17th October 2008

RE: Queensland Hunter Gas Pipeline Environmental Assessment

Muswellbrook Coal Company (MCC) would like to submit the following feedback on the above referenced project.

Figure 2m – Study Area in Muswellbrook (KP665-704)
 (Original plan supplied by the Client on 17 December 2007)

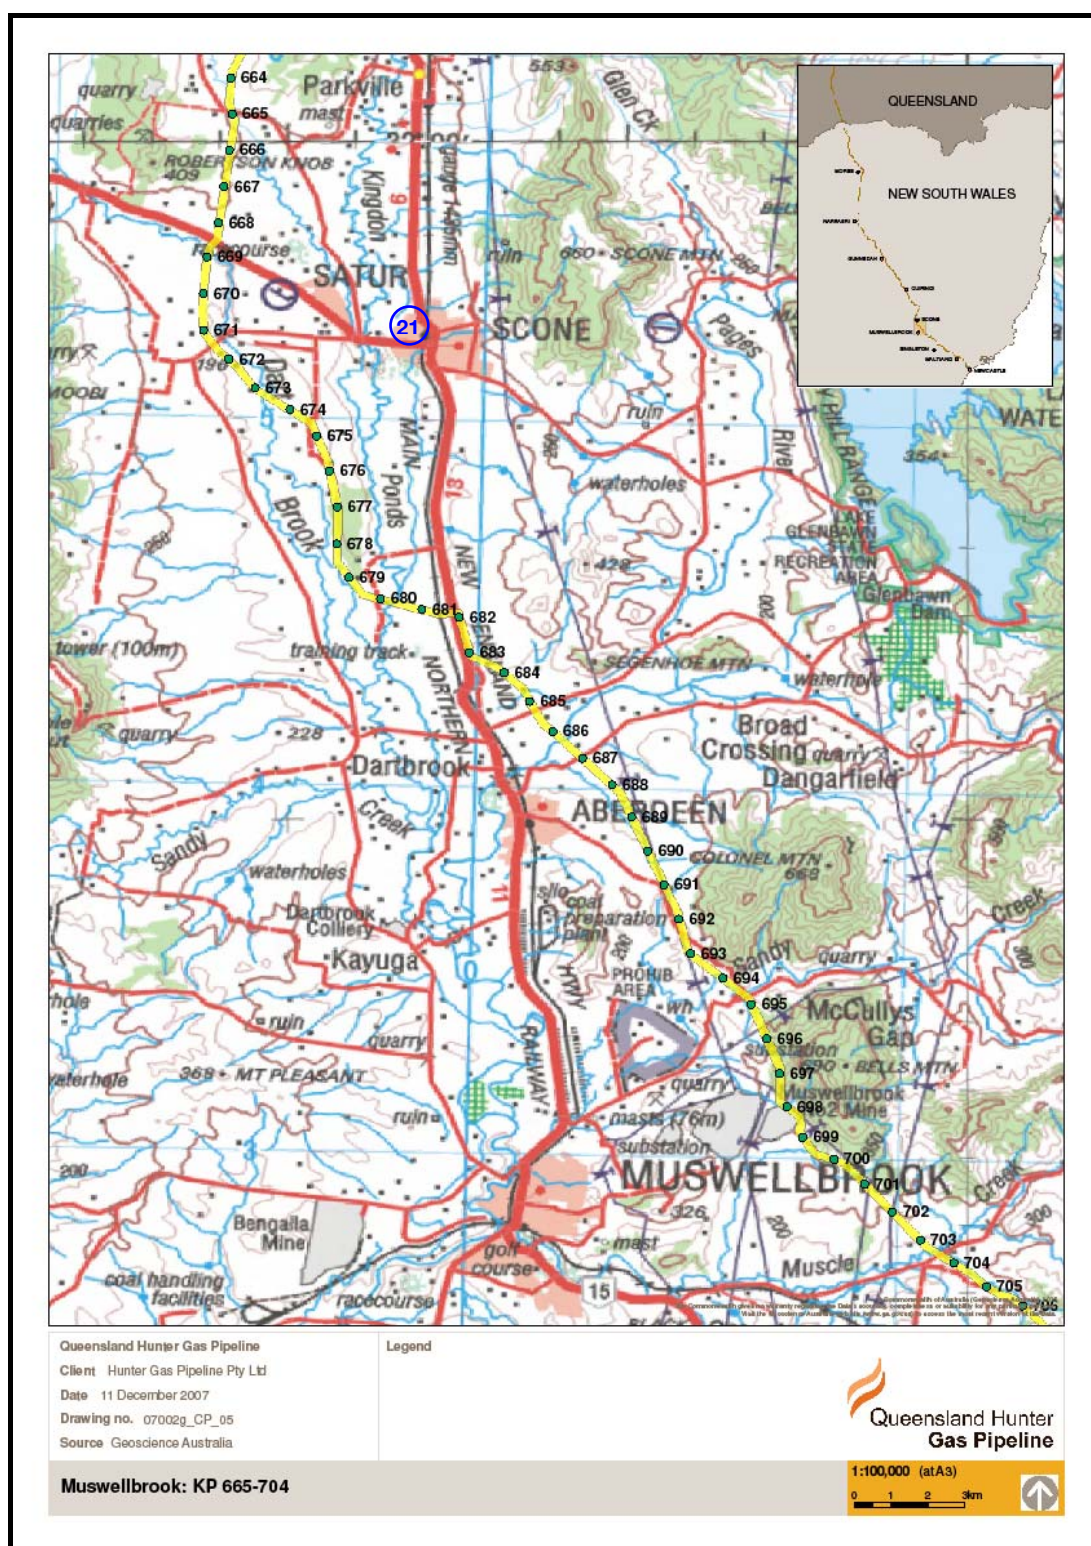
The proposed pipeline corridor runs east of our Sandy Creek Mining Area ML1513. However it does cut through the top north east corner of our Lupton Park Exploration lease A176. Both current blasting activities in our No.2 Open Cut and future Eastern Extension project need to be considered such as indemnifying MCC's operational activities from restrictions by this project.
